London Borough of Hillingdon
3 North Civic Centre
High Street
Uxbridge
Middlesex
UB8 1UW

Your Ref 75111/APP/2025/739

Proposal: Further Information - Redevelopment of site to deliver extension to existing Union Park data centre campus consisting of (a) free standing data centre building (b) energy, power, and water infrastructure (c) site access and internal roads (d) site security arrangements (e) hard and soft, green landscaping and (f) other ancillary and auxiliary forms of development

Location: Union Park UP4, North Hyde Gardens, Hayes

- KEY:
- SITE BOUNDARY
  - GRAND UNION CANAL
  - 10m BUFFER AROUND CANAL

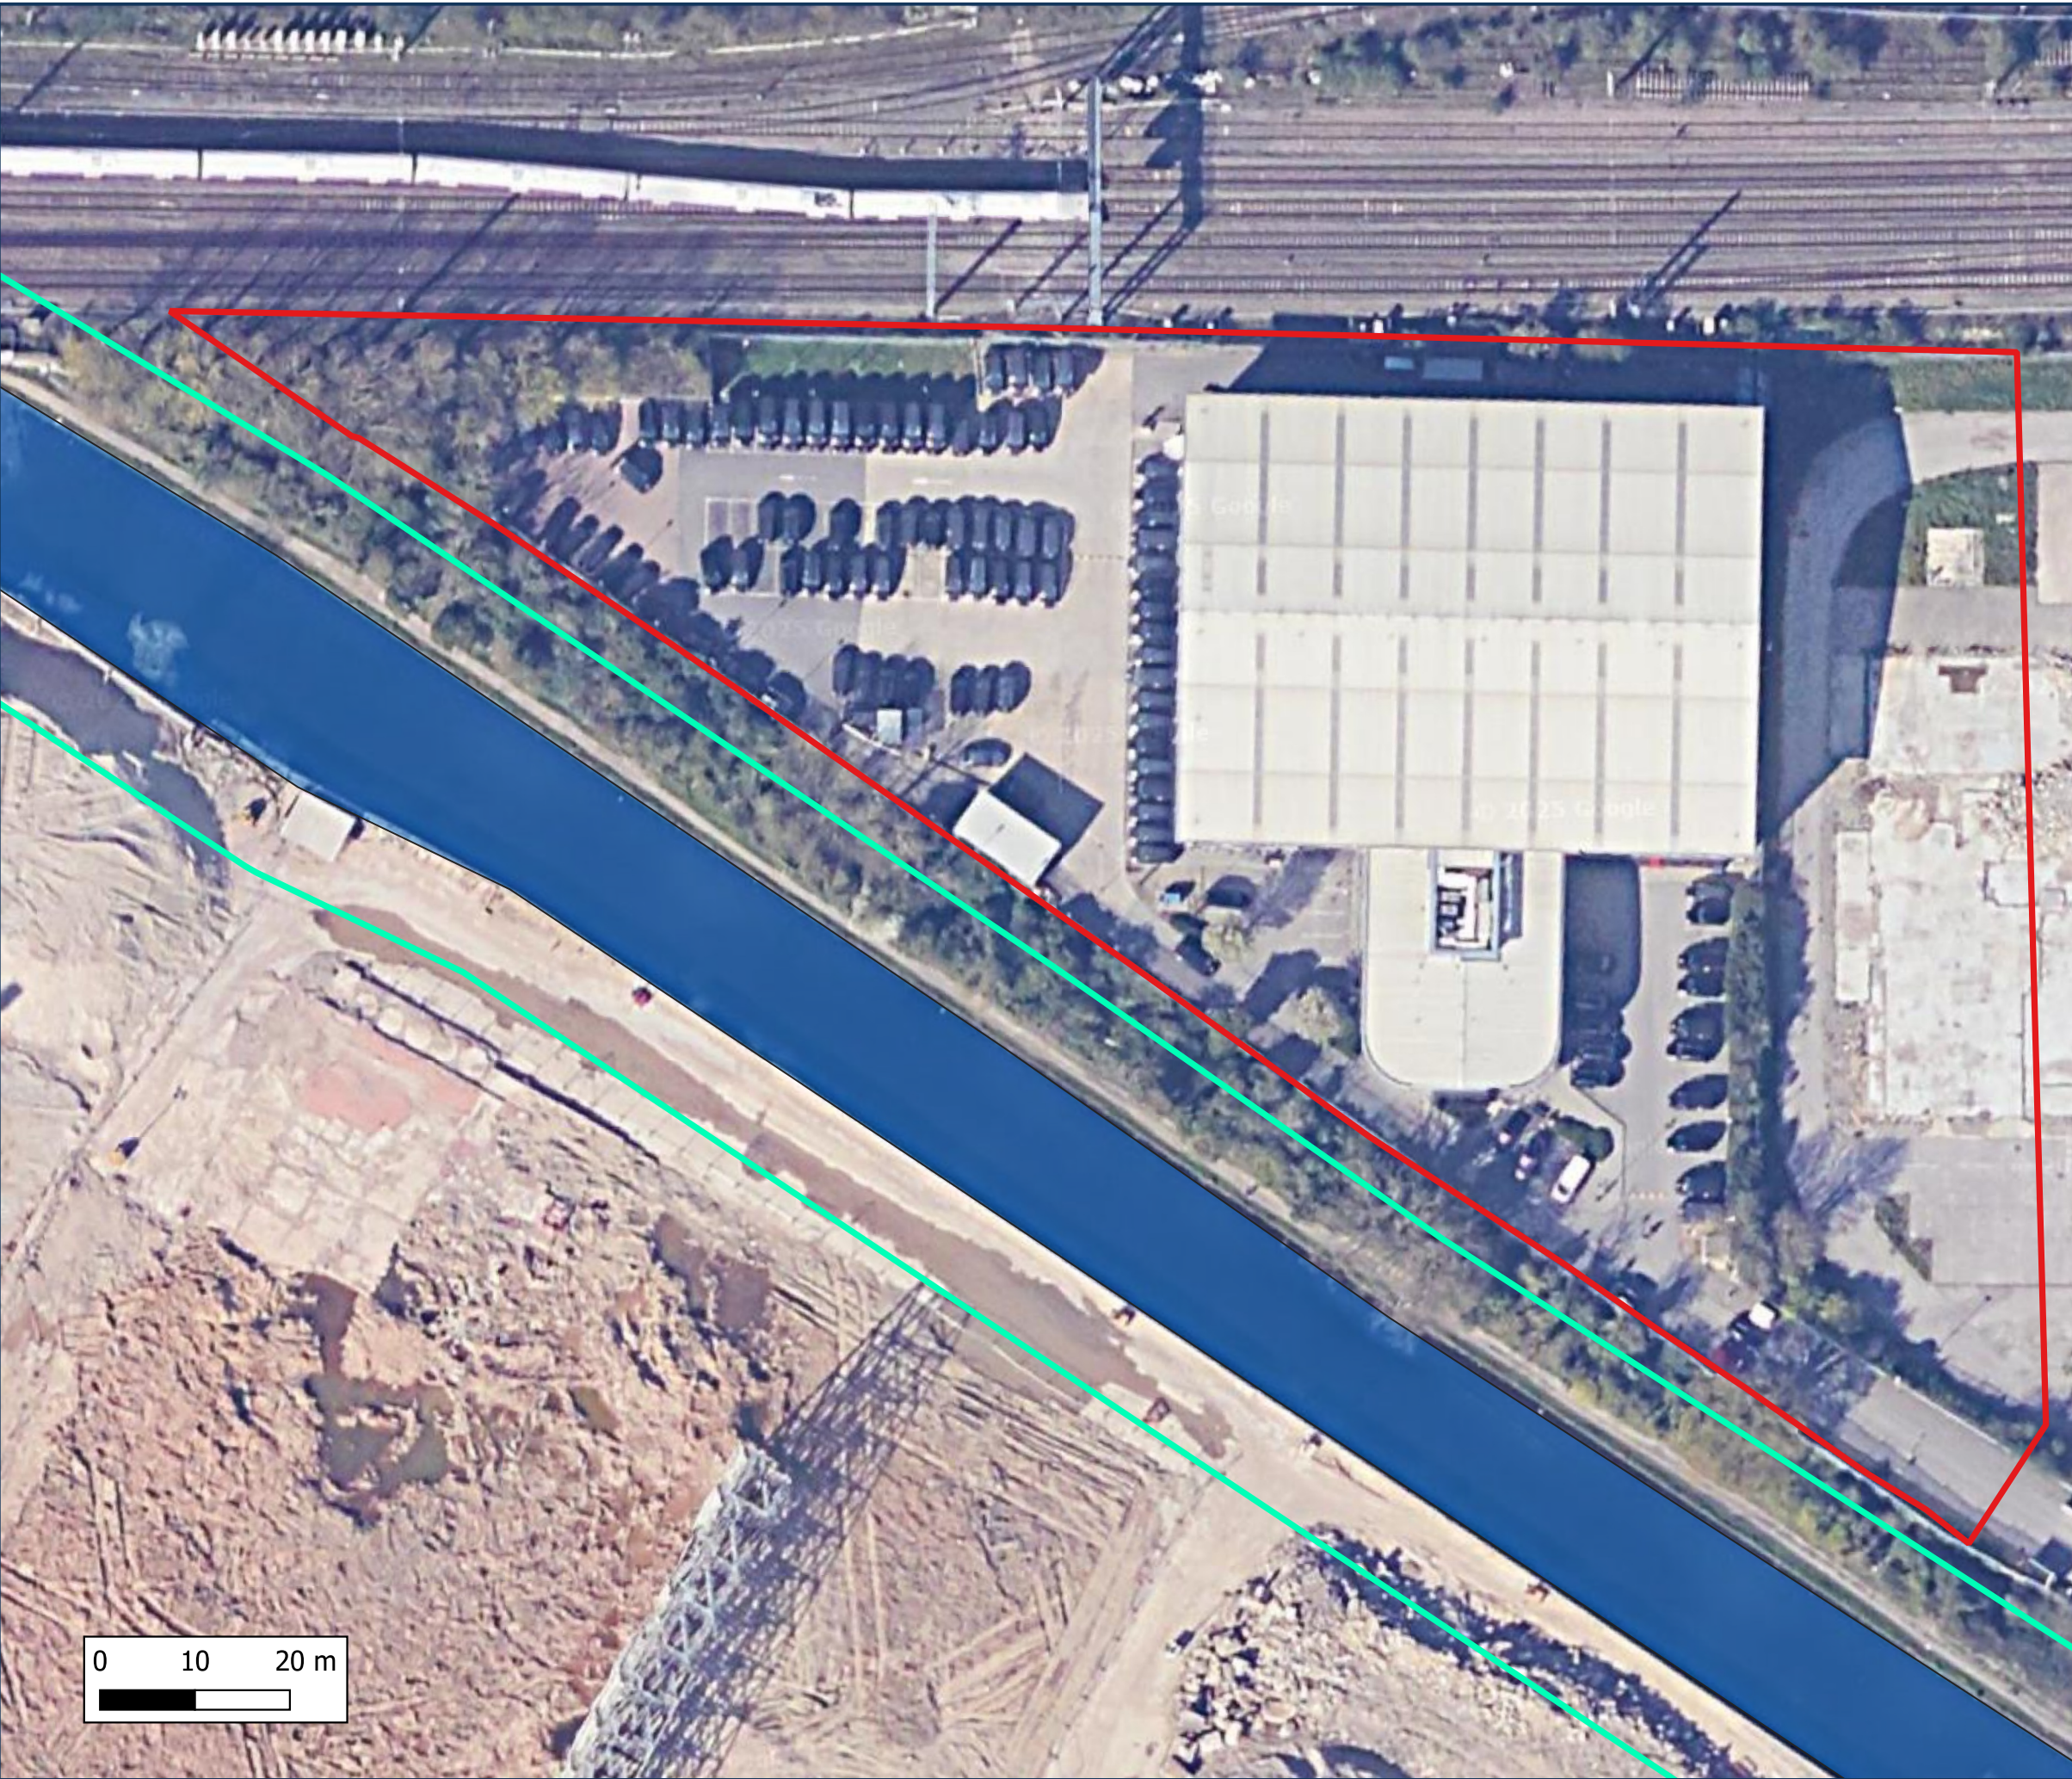
In relation to Biodiversity Net Gain (BNG) the additional information submitted states that the red line site area is more than 10m from the riparian zone of the Grand Union Canal. This would seem to leave a strip of land in-between the southern red line site boundary and the canal corridor which still appears to be within the applicant's ownership. Clarity on the proposals for that area and how it would be managed going forward will need to be provided. Nevertheless, on the basis that the red line site boundary is more than 10m from the canal bank the inclusion of watercourse units as part of the BNG assessment would not seem to be applicable.
